From: Janice Chapman
Sent: 02 November 2012 15:33
To: [REDACTED]
Subject: RE: Please find attached details of Planning decision on Application Ref: Y/36/12/

APPLICATION Y/36/12/
NO:

Site 65 Foundry Road Yapton Arundel BN18 0HE

Description of Works: Hard standing to front of property, dropped kerb & access ramp

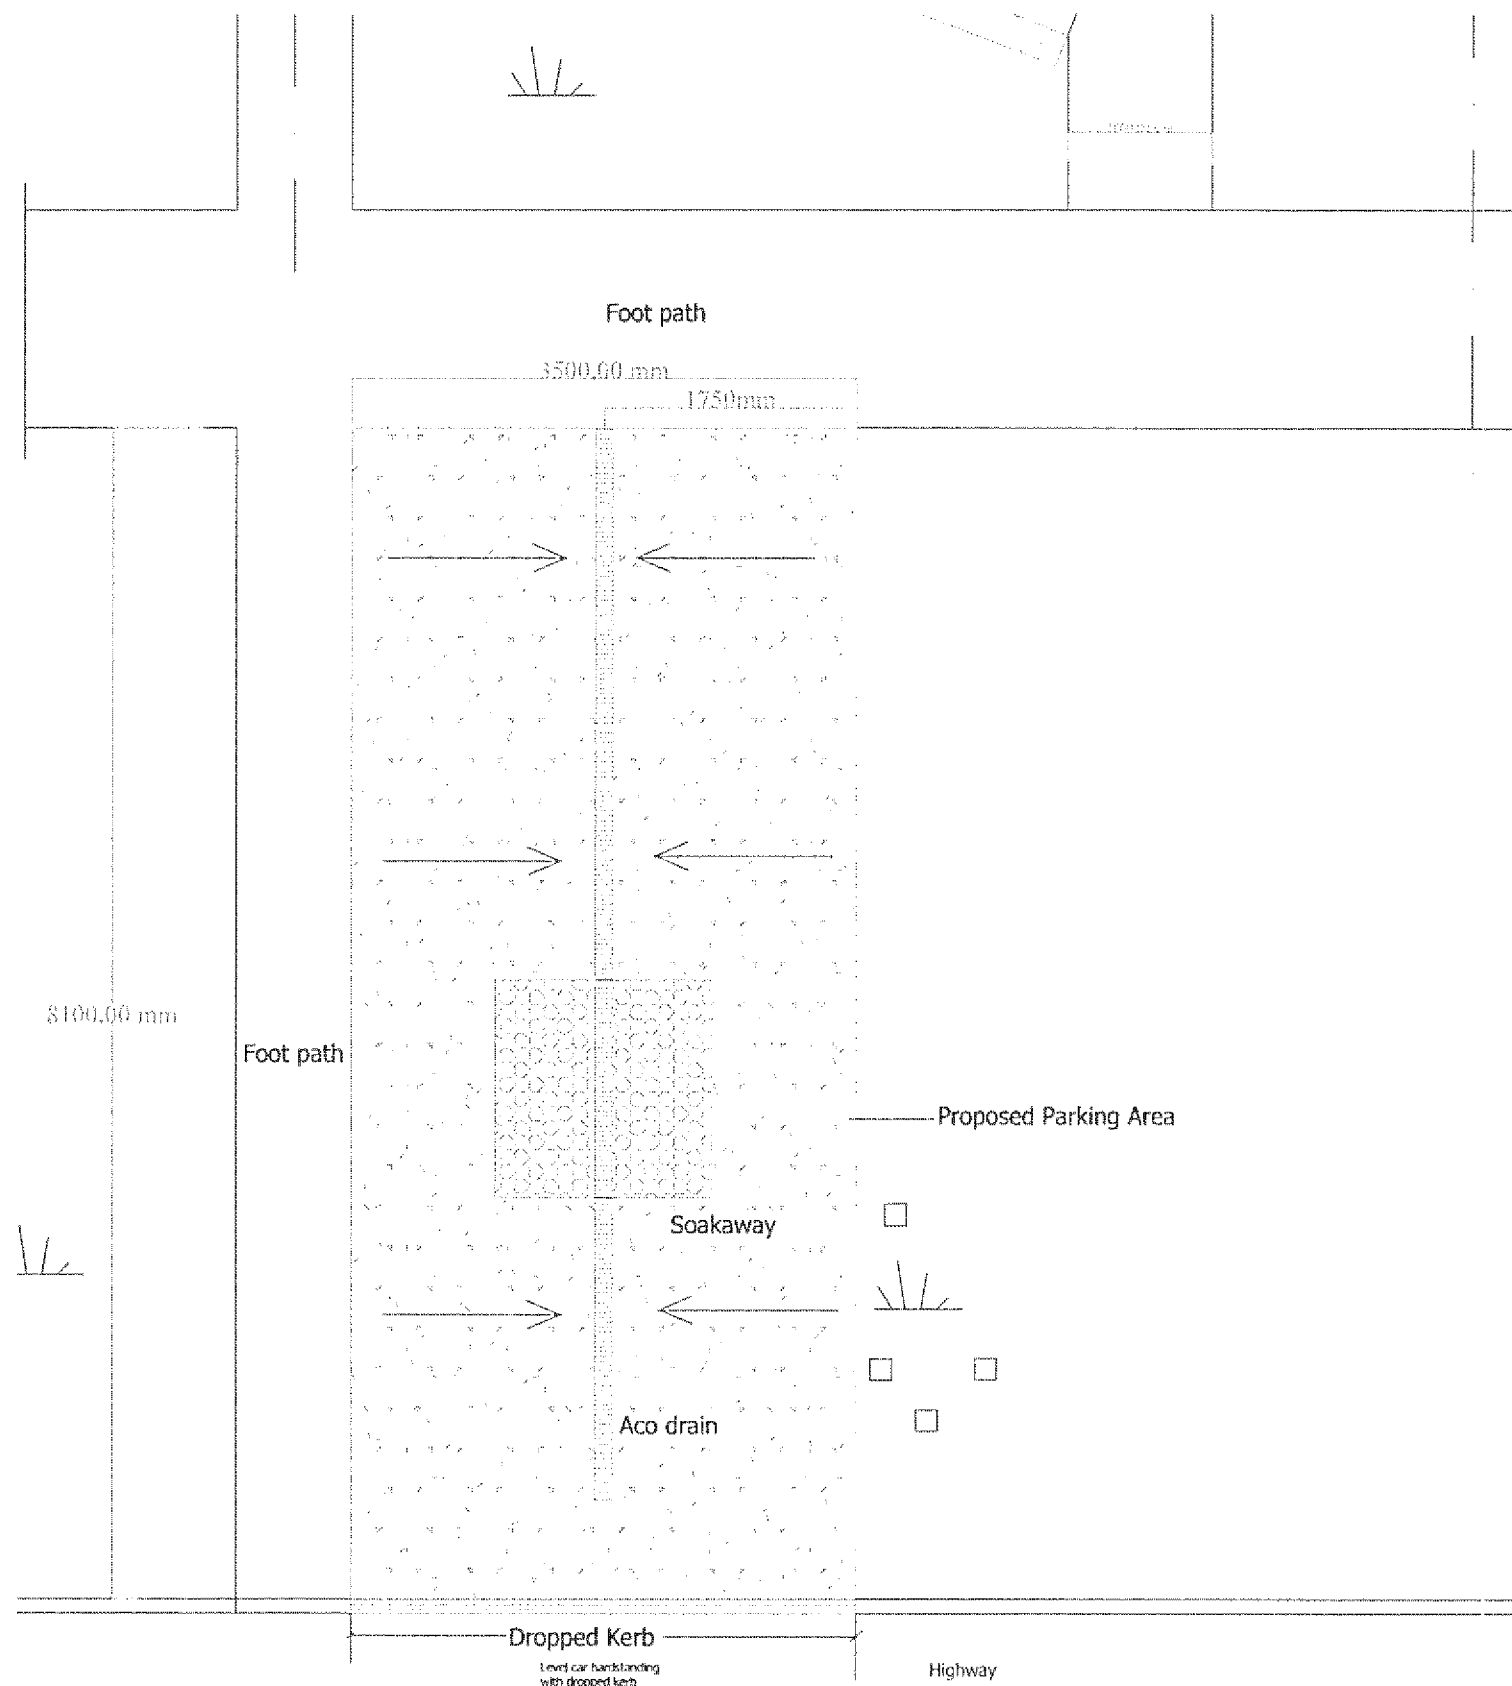
Would you please confirm that the approved hardstanding will specify a permeable/porous surface?

The application has been considered on the basis that although the hardstanding will be of concrete there will be a soakaway and aco drain system installed. It has also being taken into account that there is a vast expanse of grass to the side so provision has been made to direct run-off water from the hard surface so as to prevent surface water running direct onto the public highway.
